BCA Assessment Report

The New Primary School in Mulgoa Rise

Project:	The New Primary School in Mulgoa Rise
Reference No:	113966B-BCA-MRPS-r7
Date:	17 August 2021
Client:	NBRS Architecture
Client Contact:	Johnsen Lim
Email:	johnsen.lim@nbsarchitecture.com
BCA Logic Contact:	Alex Newberry
Direct:	0466 811 720
Email:	anewberry@bcalogic.com.au

Drawing Title
BLOCK C - GF PLAN

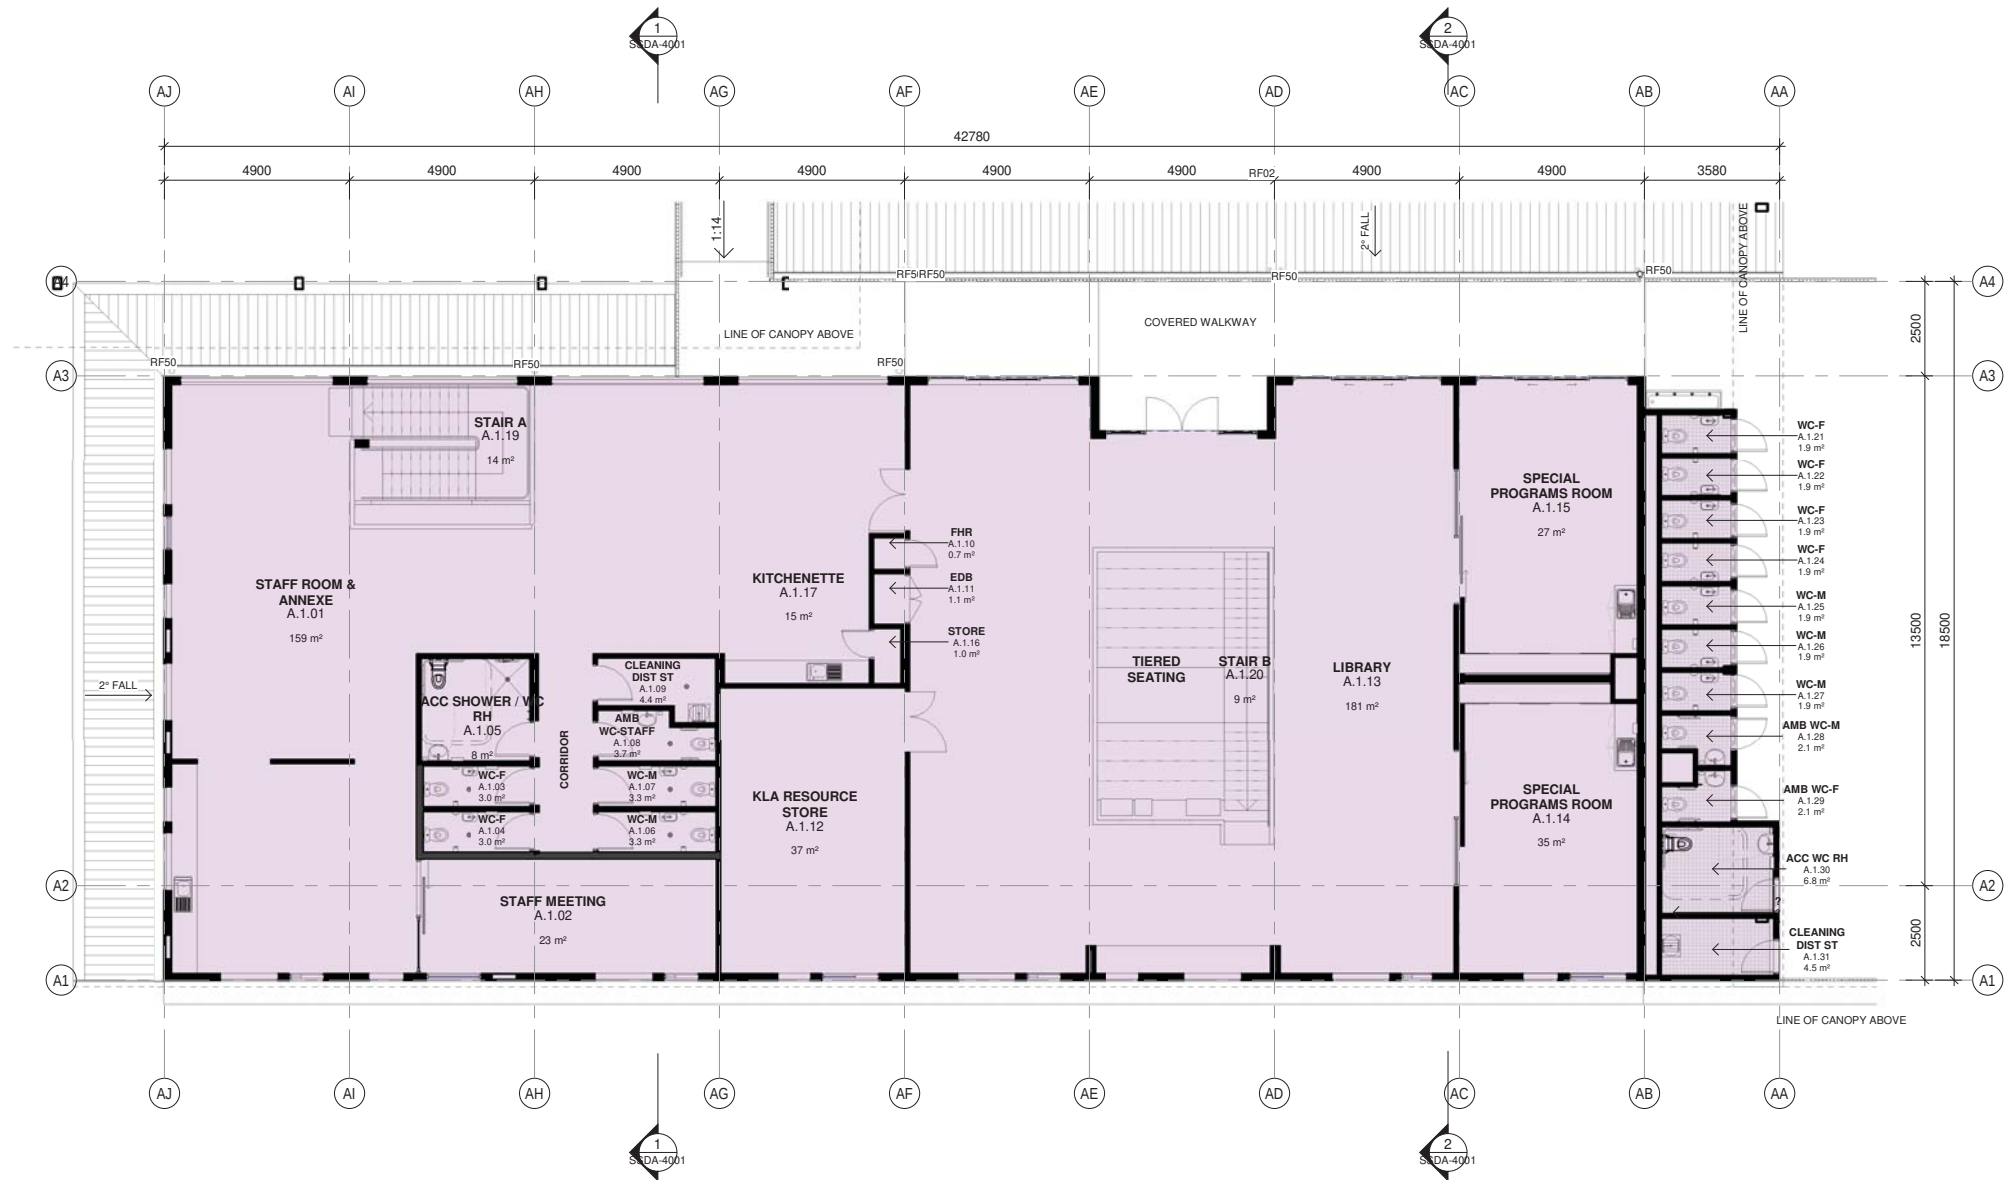
- The stage must be less than 50m² to avoid having smoke-and-heat vents under NSW Table E2.2b. The whole floor area of the stage shall be counted as the BCA definition of floor area, however excluding the landing areas of ramp and stairways with handrail extensions/tactiles. Refer below for a proposed solution to extend the corridor wall to exclude the corridor and turning space landing from the calculation of the stage area, which results in less than 50m² floor area.

- Confirm the seating across the front of the stage are designed to be tiered seating area in accordance with BCA Clause H1.4. The stage already has two stairways which will be accessible with handrails & TGSIs. When tiered seating is designed as per H1.4, handrails and TGSIs are not required. Clause H1.4 tiered seating requires greater heights between seating platforms than a stairway. Alternatively, if the client wants it to be a stairway across the front it will require handrails both sides and TGSIs across the full width top and bottom.
